November 19, 2021

RE: Village at Waterview North - EGP214

The Development Drainage Preliminary Drainage Report dated July 15, 2021 and supporting drainage documents has been reviewed by a CDOT Hydraulics Engineer and their comments are:

DESIGNED BY: **JM** DATE: **06.18.21**
DRAWN BY: **JAZ** DATE: **09.20.21**
CHECKED BY: DATE:

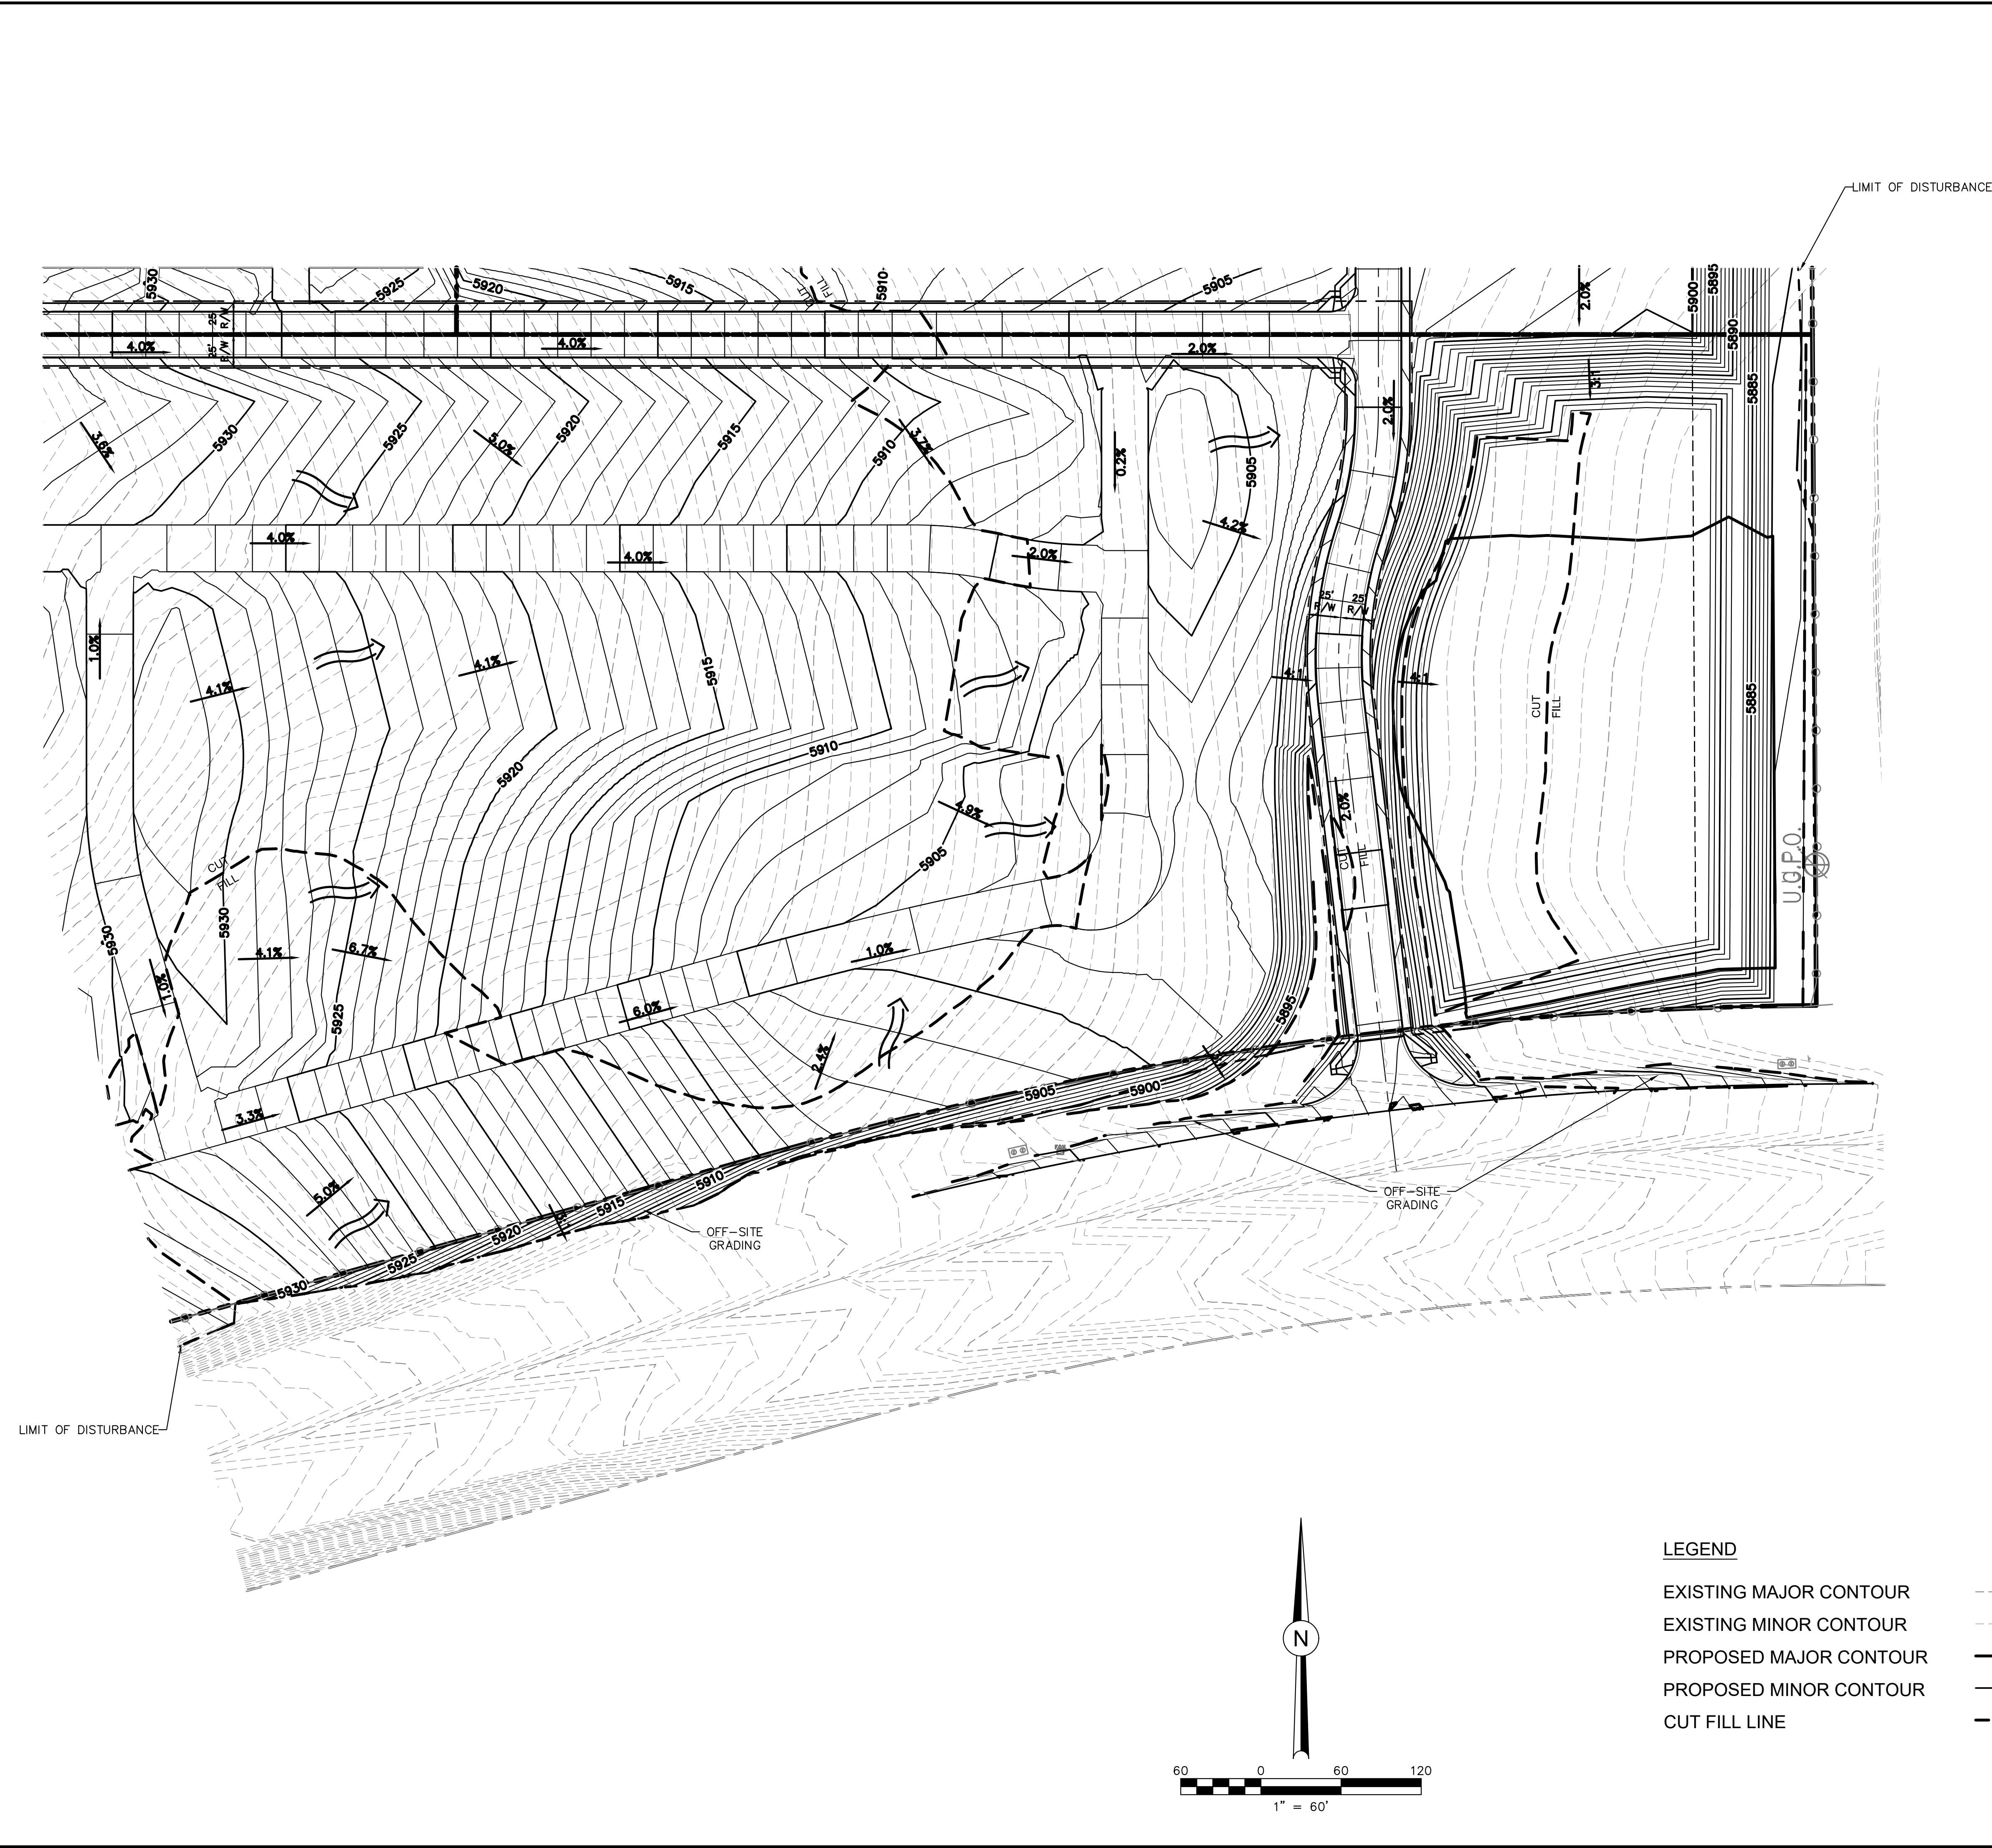
- On the grading and SWMP plans, the existing contours don't have elevations.
- There appears to be a pond/permanent sediment basin in the grading file in the NW corner, but it is not discussed in the drainage report.

- The pond grading appears to show an overflow spillway that would discharge onto CDOT ROW. This needs to have a maintenance agreement associated with it.
- There is no storm infrastructure shown on the plans, it cannot be determined if all flows leave the site away from Powers or if there is discharge into CDOT ROW.
- There is an existing CBC under Powers that is not discussed in the report. It cannot be determined the culvert is adequately sized in the existing, and if flows from the planned development will impact CBC capacity.
